K/19/19/HH – Little Tangle, Middle Way, East Preston BN16 1SB

We write in connection with the planning application K/19/19HH.

Drawing Title
**Existing and Proposed
Floor Plans**

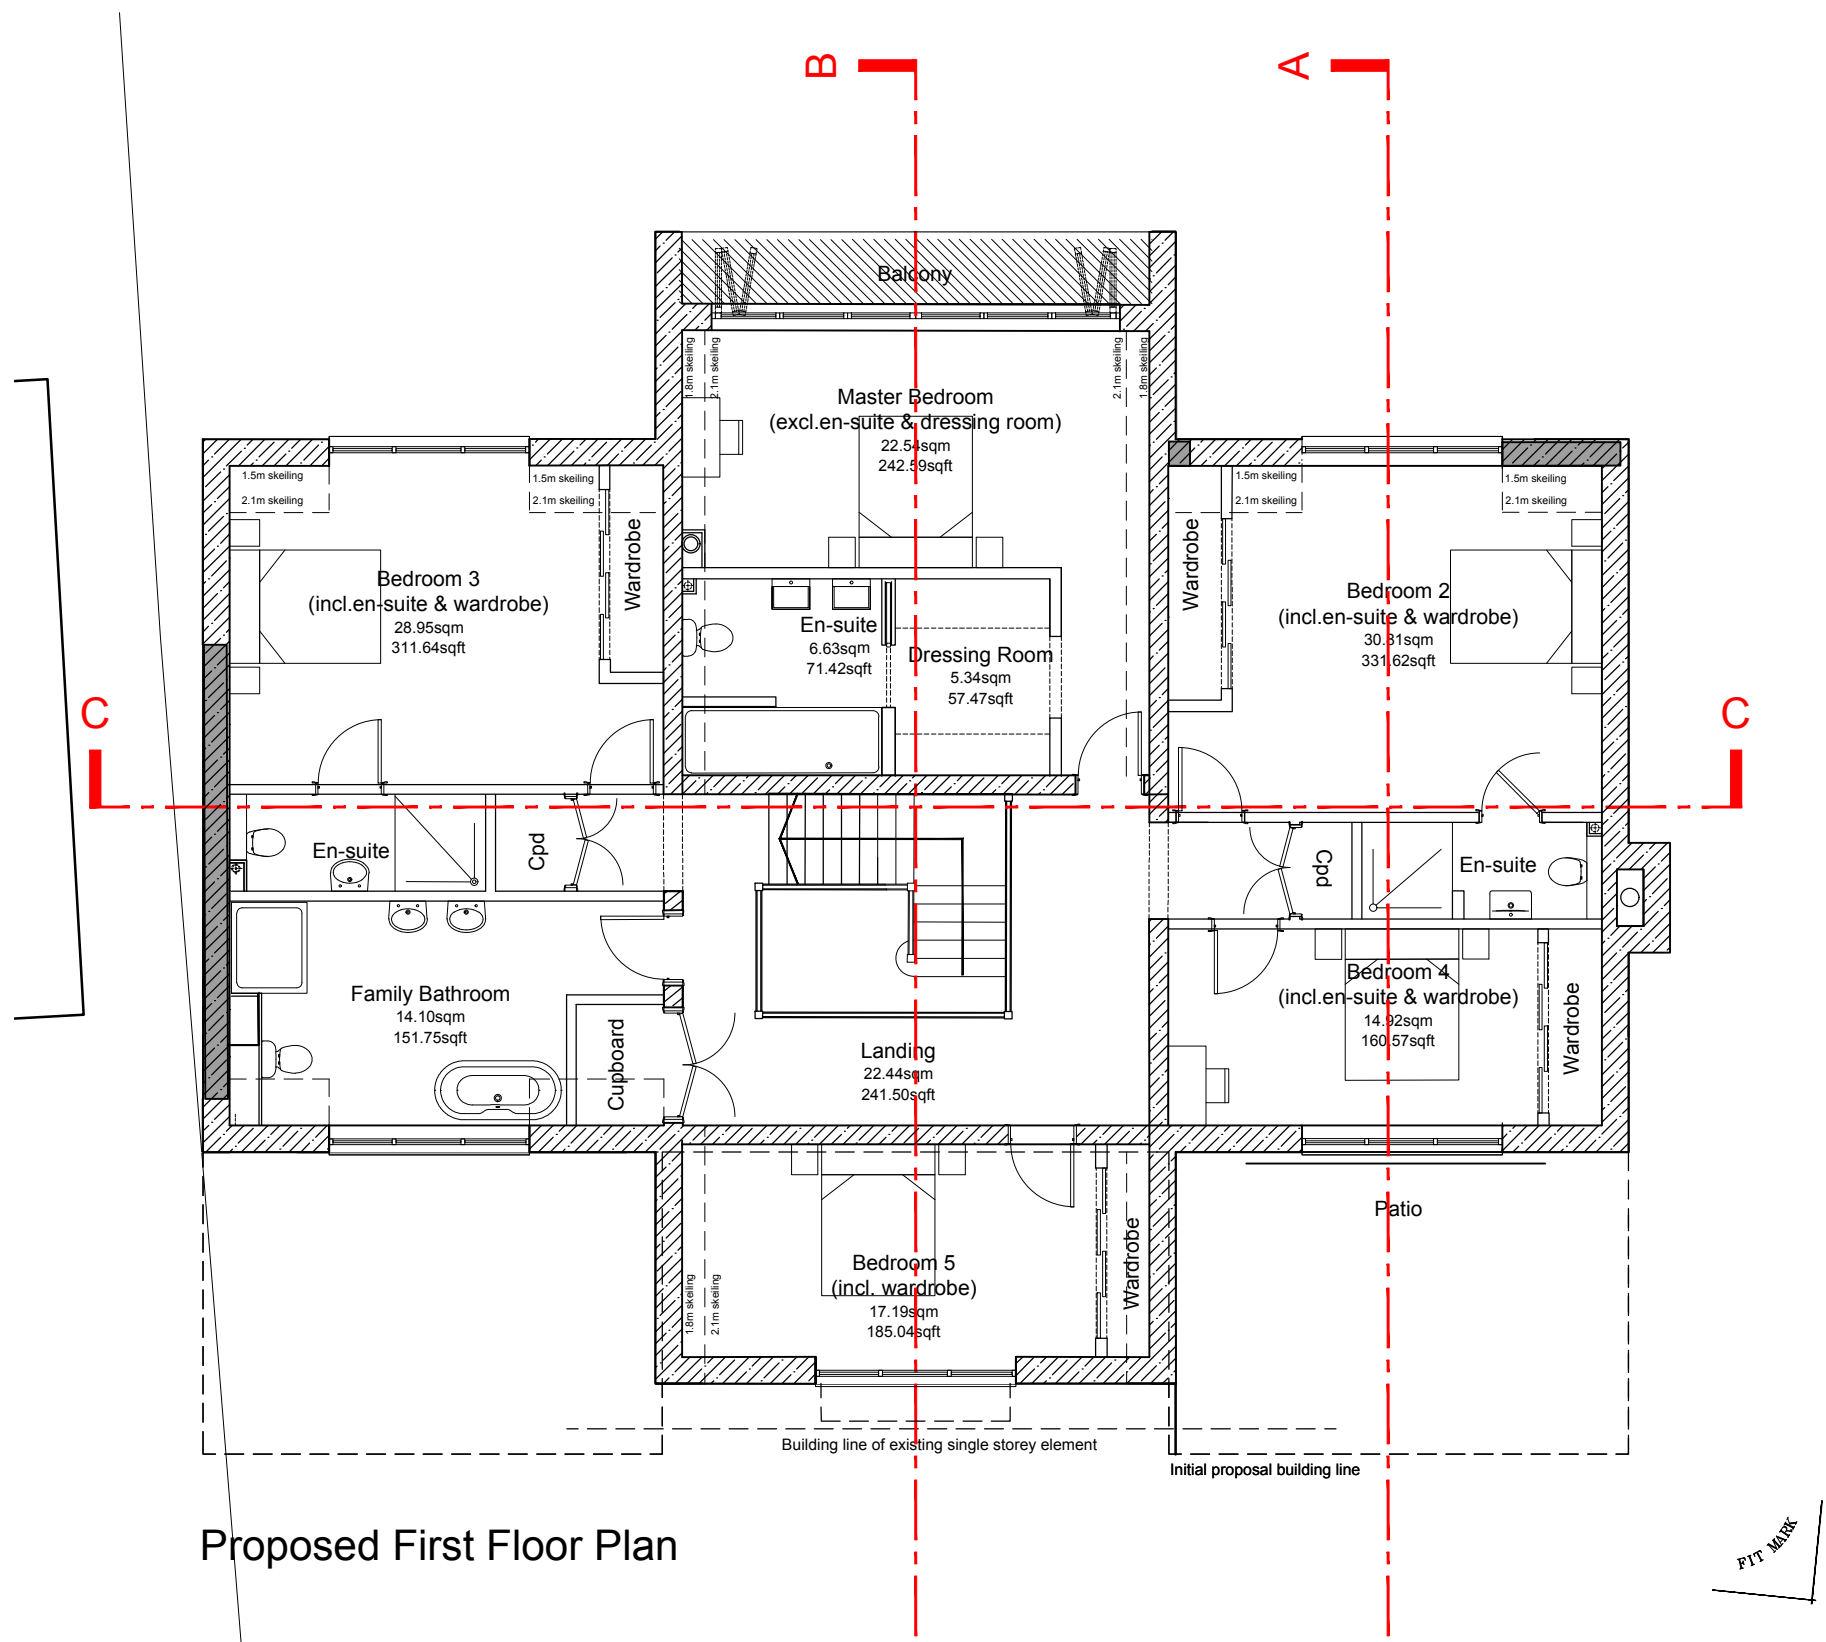
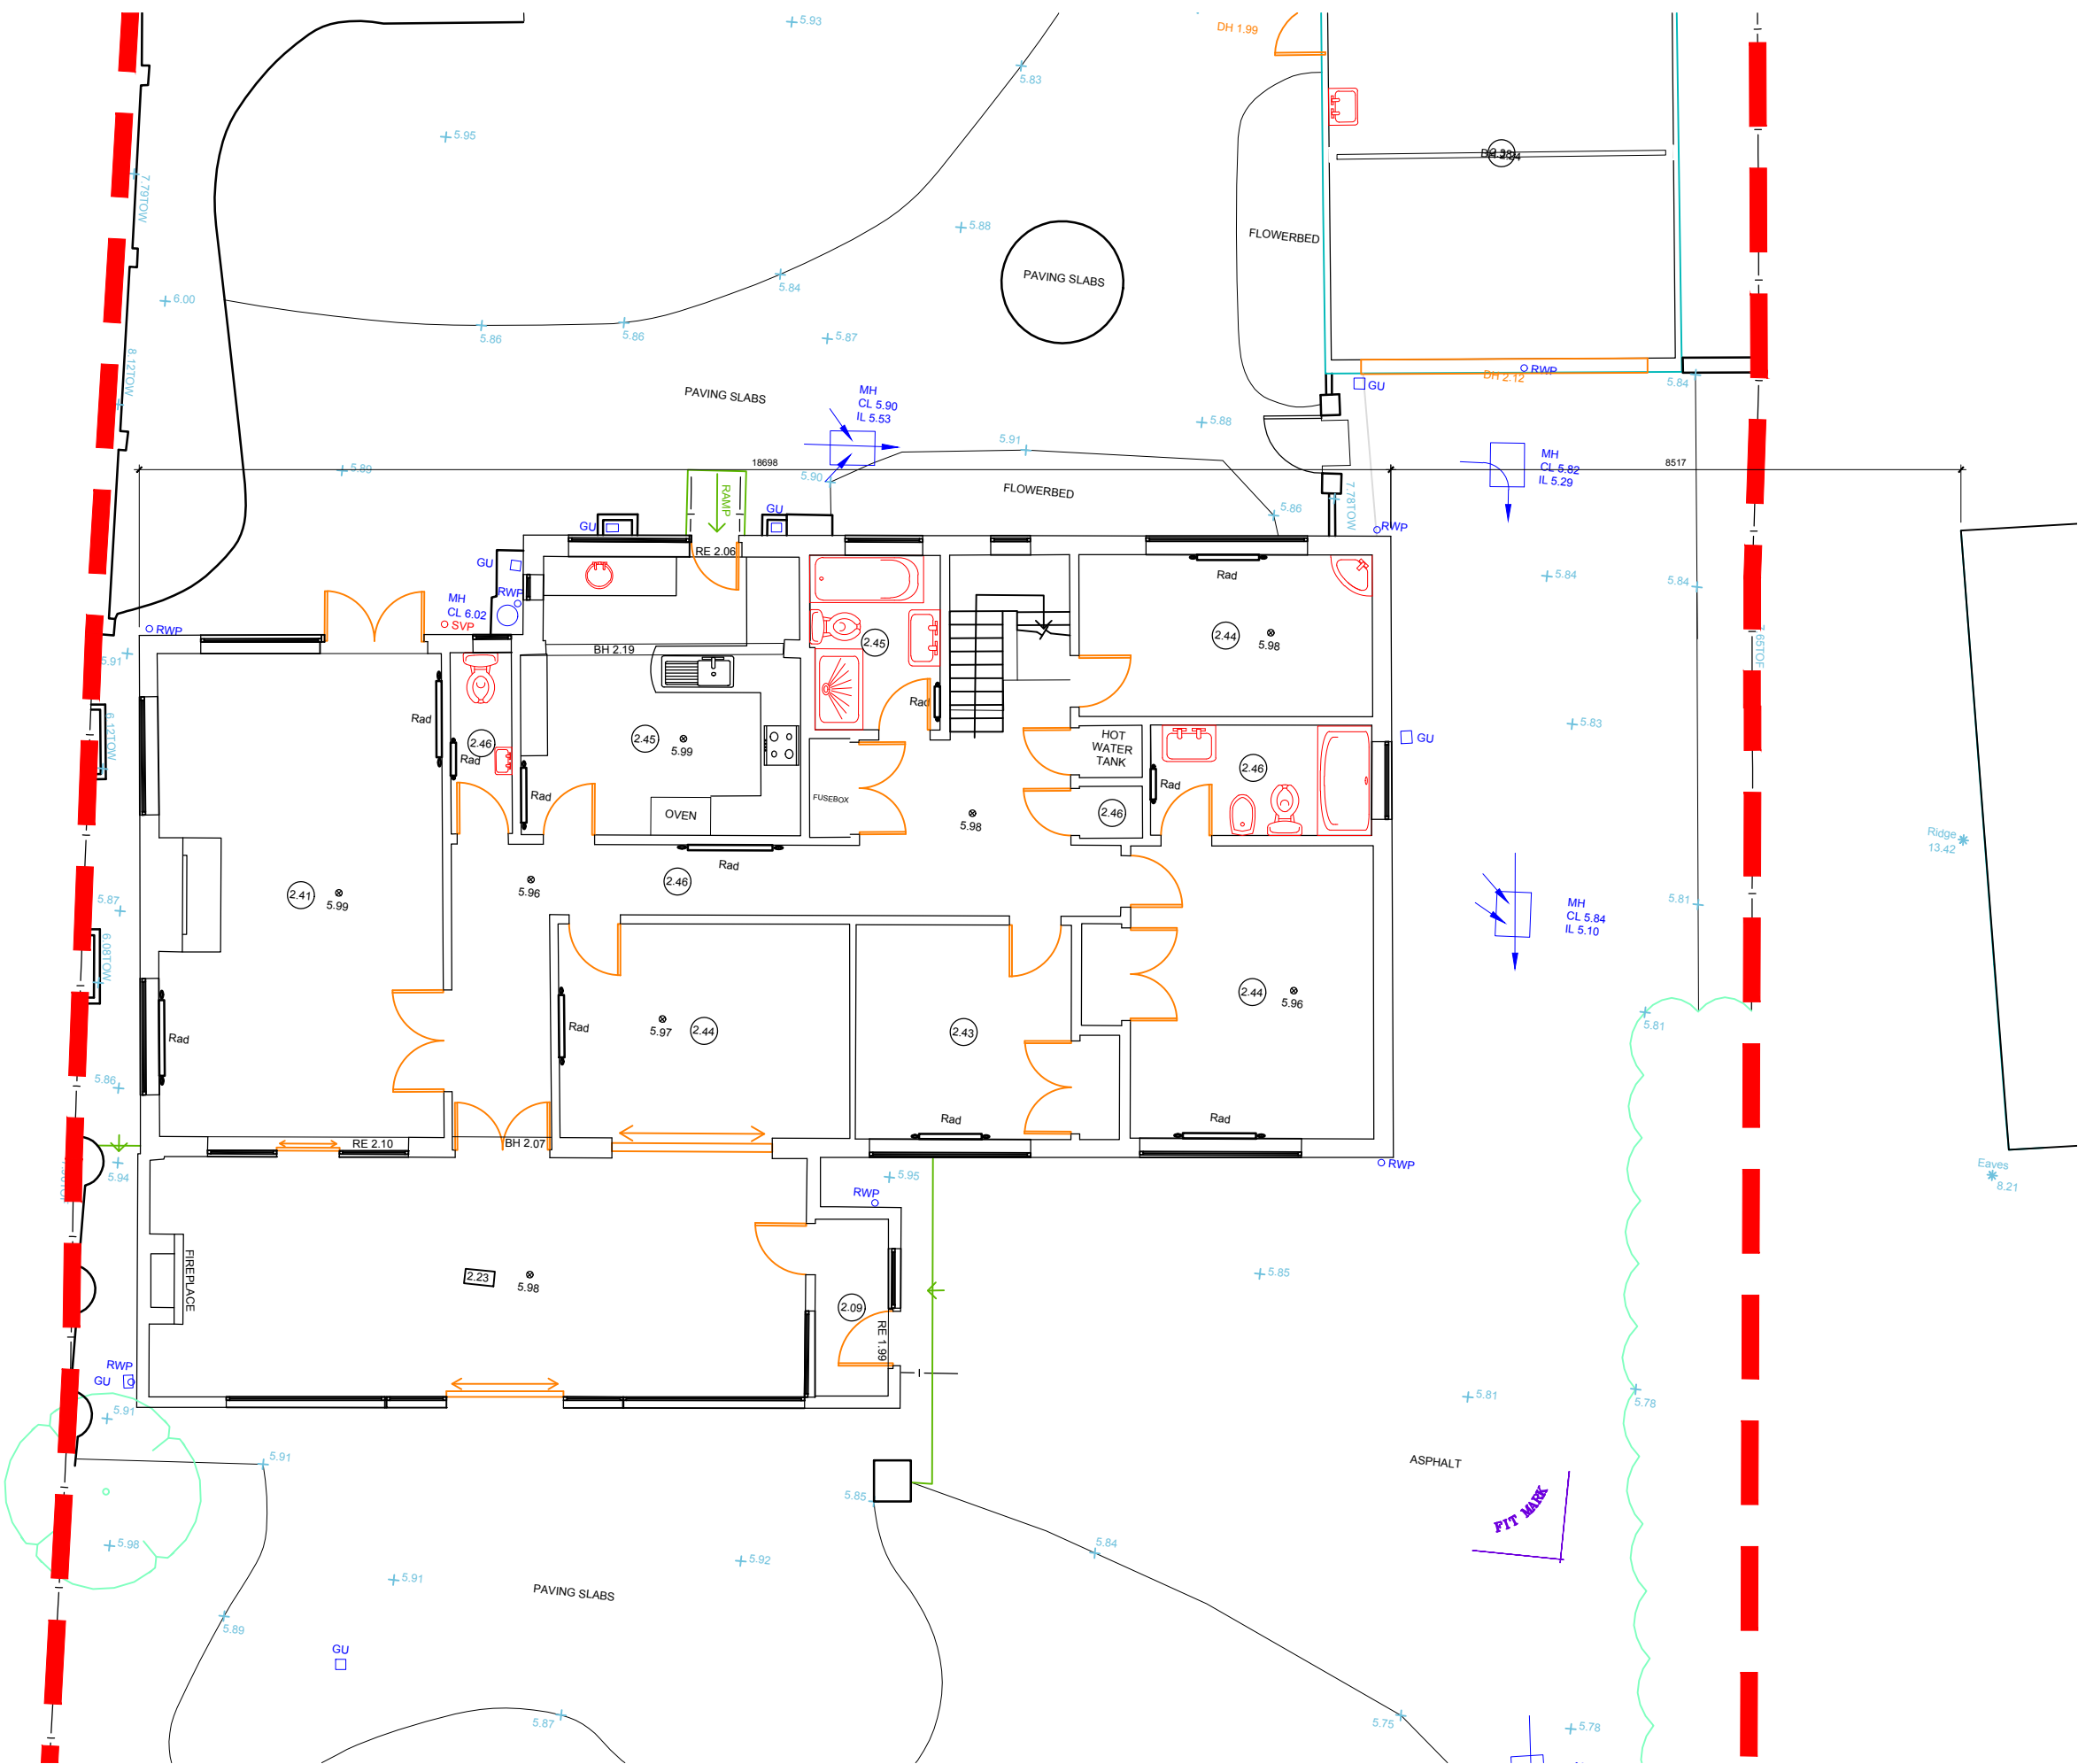
3. Whilst the ground floor m2 footprint is relatively unchanged, the shape of the footprint is different to today. The proposed rear development extends the footprint beyond the line of the current building and that of The Poynings, this is compounded by the fact that this will be a 2-storey extension 3.4m higher than it is today and 2m higher than The Poynings.

Most significantly we believe the rear bedroom/balcony gable element of the building would extend at least 1.5m beyond the line of The Poynings.

4. There is to be a window on the ground floor east elevation. One exists today but it is small, opaque and virtually invisible due to the height of the side fencing. It is unclear from the drawings if this is to be maintained or changed in anyway i.e. size, glass type etc. We are assuming any planning approval would require the current level of privacy to be maintained.
5. We note that there is to be no change to hedging given there is a substantial hedge on the east boundary that screens Little Tangle from The Poynings. The comments in the Design and Access statement are somewhat contradictory as they state there will be no changes to hedging and fencing and then go on to say that there will be. We would welcome clarification of what is intended.
